KIRKLEES METROPOLITAN COUNCIL INVESTMENT & REGENERATION SERVICE

Reference No:	2025/44/91211/E
Site Address:	east of, Mill Lane, and Heaton Grange, Hanging Heaton, Batley, WF17 6EN
Description:	Discharge of details reserved by conditions 6 (road specification), 7 (retaining walls), 8 (highway structures), 10 (noise assessment report), 17 (drainage strategy), 18 (surface water discharge), and 19 (storm events) on outline permission 2020/93777 for erection of residential development
Recommending Officer:	Katie Chew

Application: 2025/91211

Proposal: Discharge of details reserved by Conditions 6. (road spec) 7. (retaining walls) 8. (new surface water) 10. (noise assessment report) 17. (drainage) 18. (surface water discharge) & 19 (storm events) of outline permission 2020/93777 for erection of residential development.

Title: **PROPOSED DRAINAGE GA**

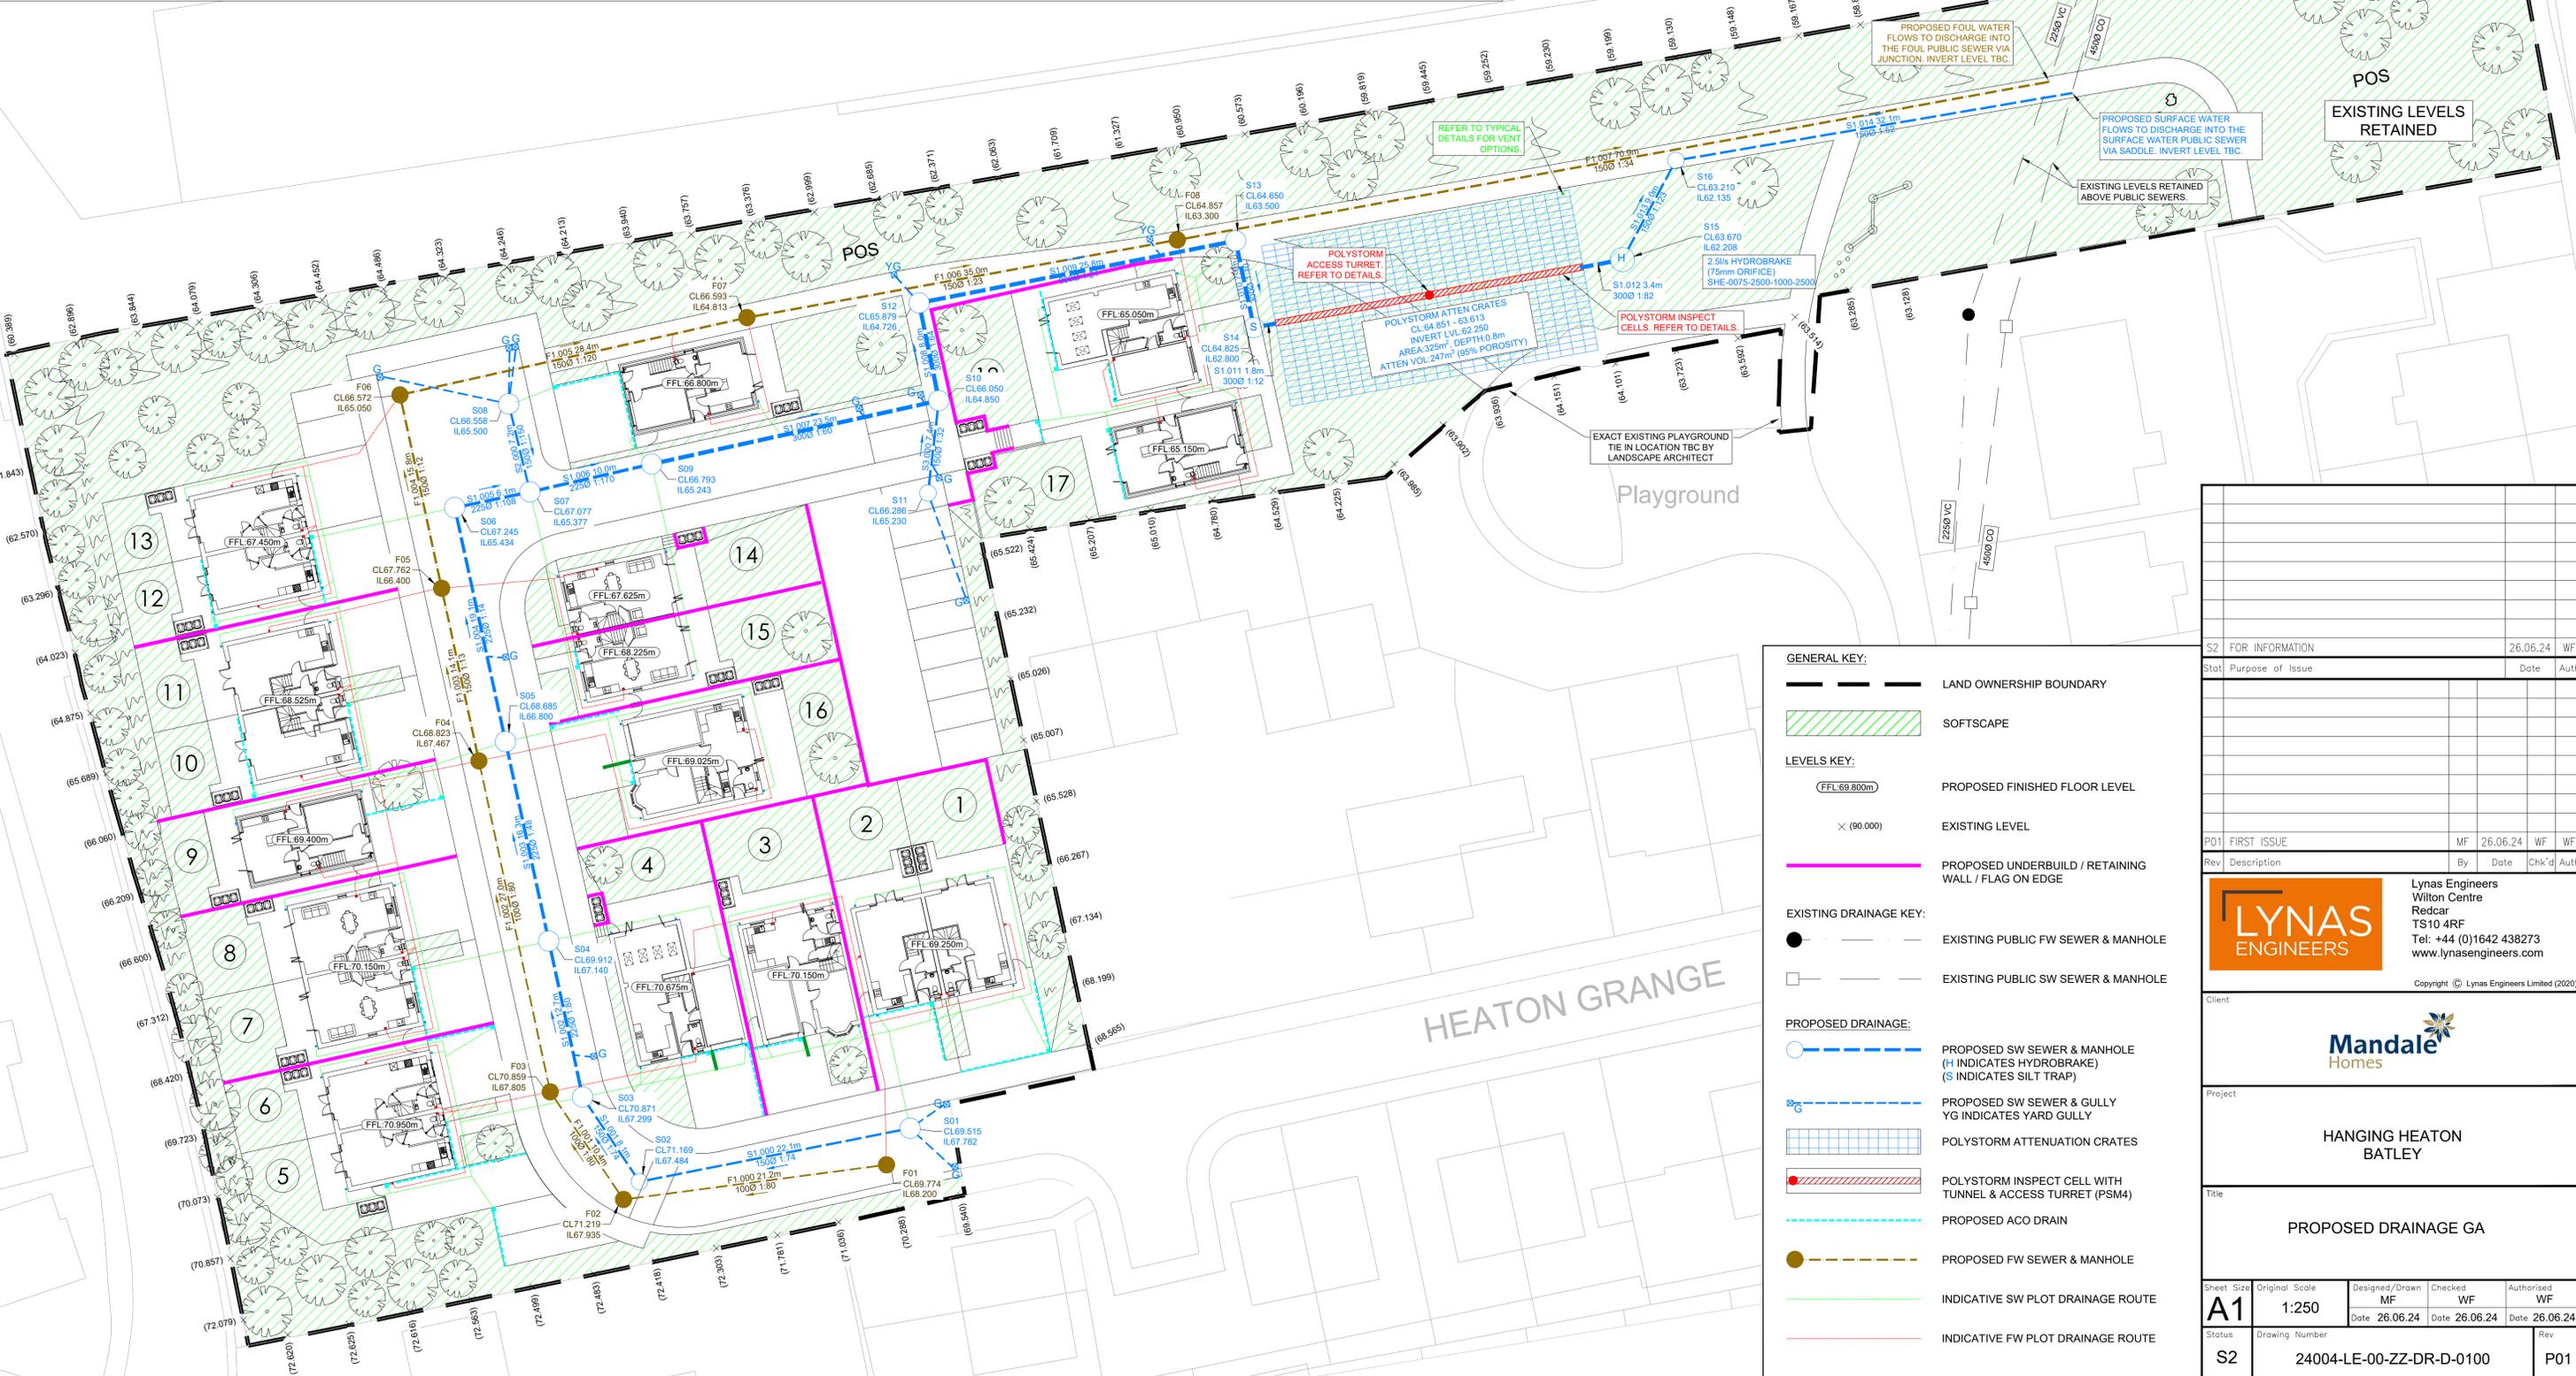
The proposed drainage as detailed on the Proposed Drainage GA drawing is generally acceptable to the LLFA; it is suggested, however that the silt trap MH upstream of the attenuation tank should be MH S10 rather than S14 (or both) as stated in the Drainage Strategy and detailed on the Typical Attenuation Tank Details drawing as this MH will be more easily accessible during desilting operations.

*Also, this MH should be clearly noted on the Proposed Drainage GA as a silt trap MH to ensure the Contractor installs the correct type. These suggested changes should be incorporated into the Construction drawings and the drawing does not need to be re-submitted to the LLFA. Therefore, the LLFA confirms that Condition 17 **can** be discharged.*

- *the silt trap MH upstream of the attenuation tank should be MH S10 rather than S14 (or both) as stated in the Drainage Strategy and detailed on the Typical Attenuation Tank Details drawing as this MH will be more easily accessible during desilting operations.*
- *Also, this MH should be clearly noted on the Proposed Drainage GA as a silt trap MH to ensure the Contractor installs the correct type.*
